**From:** Boryn, Agnes <agnes.boryn@westyorkshire.police.uk>  
**Sent:** 21 October 2025 15:11  
**To:** Danielle Cooper; DC Admin  
**Subject:** DOCO comments for application 2025/92331 at Almondbury Working Mens Club, Southfield Road, Almondbury, Huddersfield, HD5 8RY

Proposed Ground Floor Plan

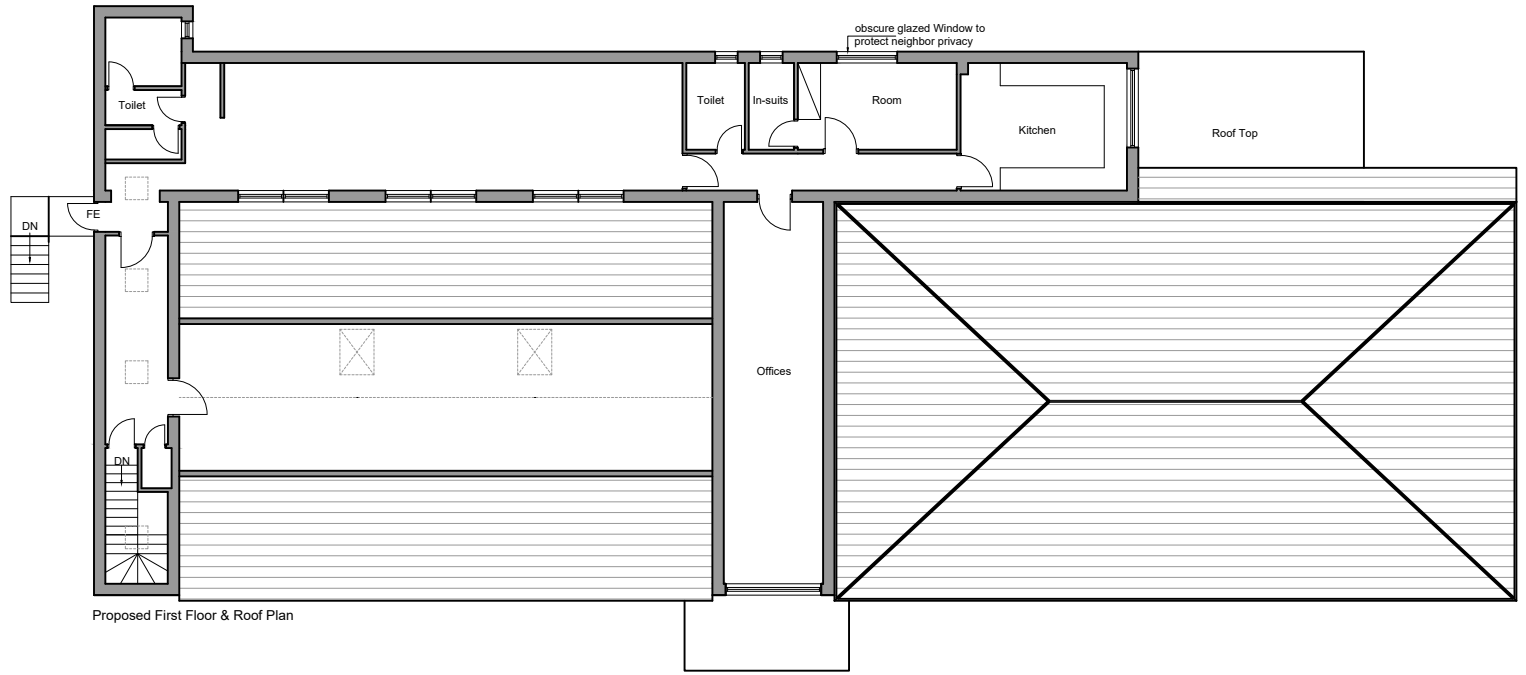
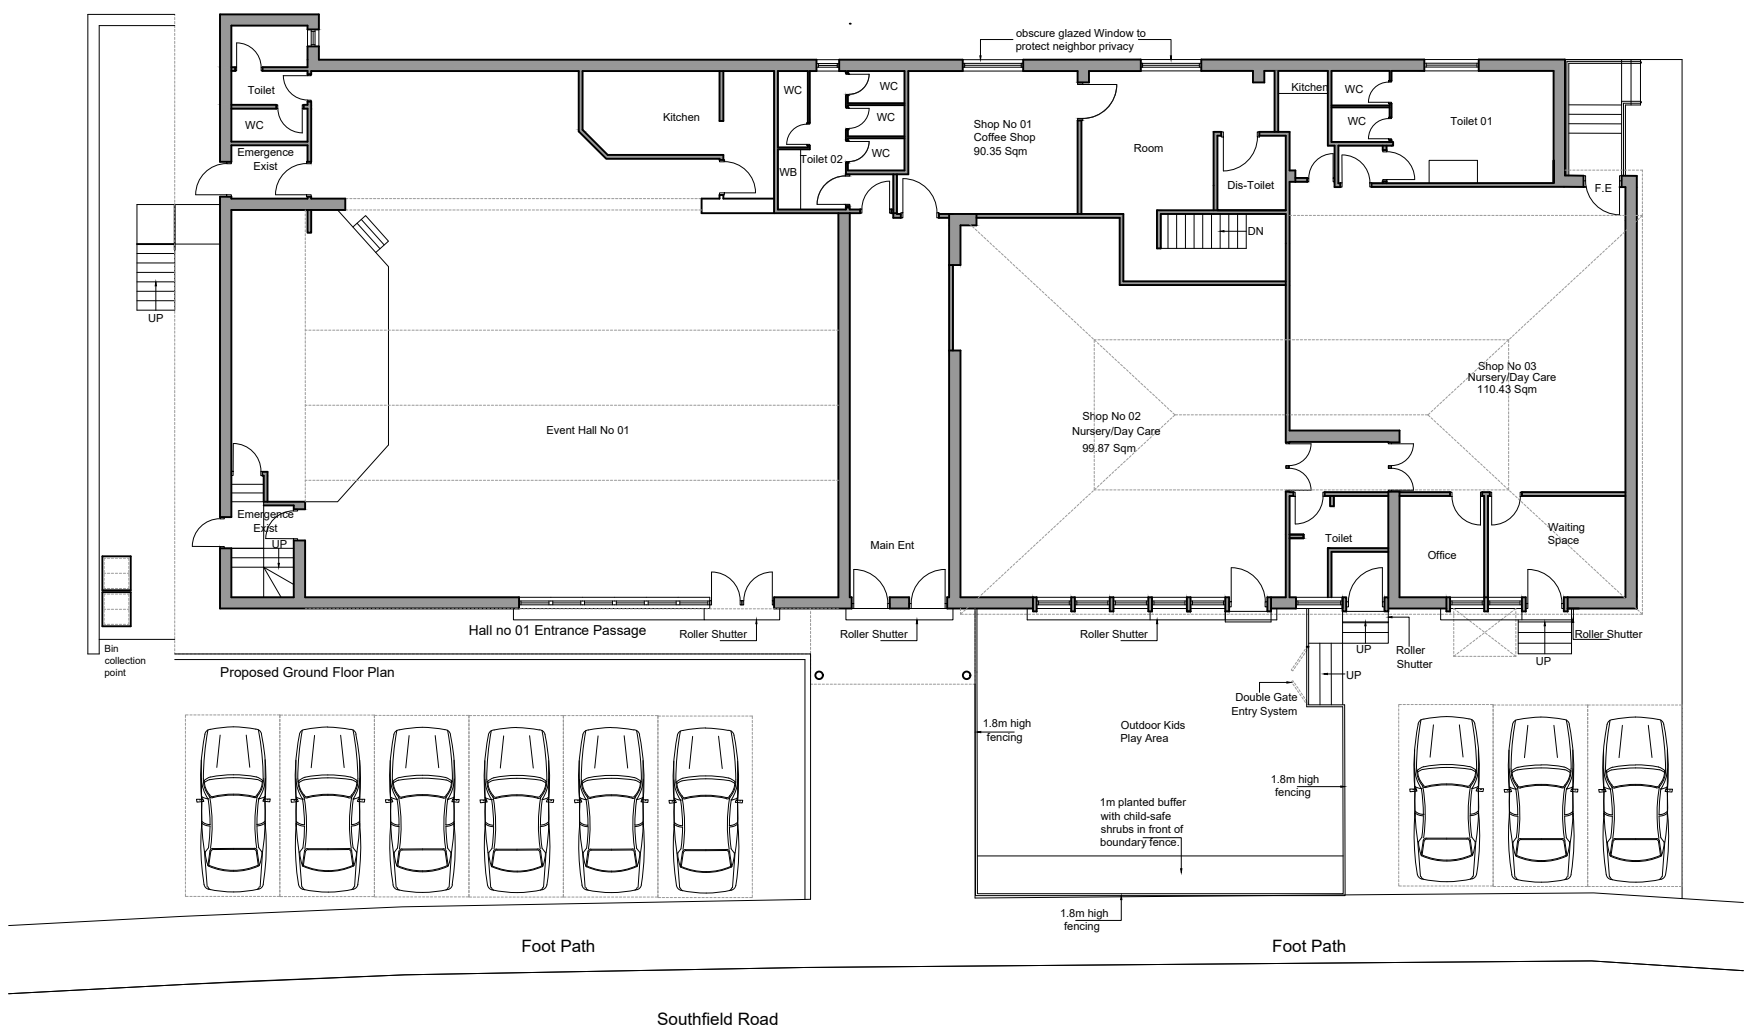
1. **Condition 2 (plans)**- I would like to see the design of proposed fencing to the outdoor play area; this should be at least 1.8m high and free from climbing aids, footholds and cross members.

The roller shutter at the front should be rated to one of the below standards as a minimum:

In the event of an emergency, it must be possible to secure electrically operated roller shutters and grilles quickly from a safe location within the premises. For example, the ability to operate a closing mechanism for shop front roller shutters from a safe area at the rear of the premises.

Additionally, the applicant is urged to consider installing bollards along the following lines (marked in blue):

This is to protect the children and staff from vehicular threats- whether intentional or accidental. The bollards should be rated to ISO 22343-1. ISO 22343-2 provides guidance on the appropriate selection, installation and use of such bollards.
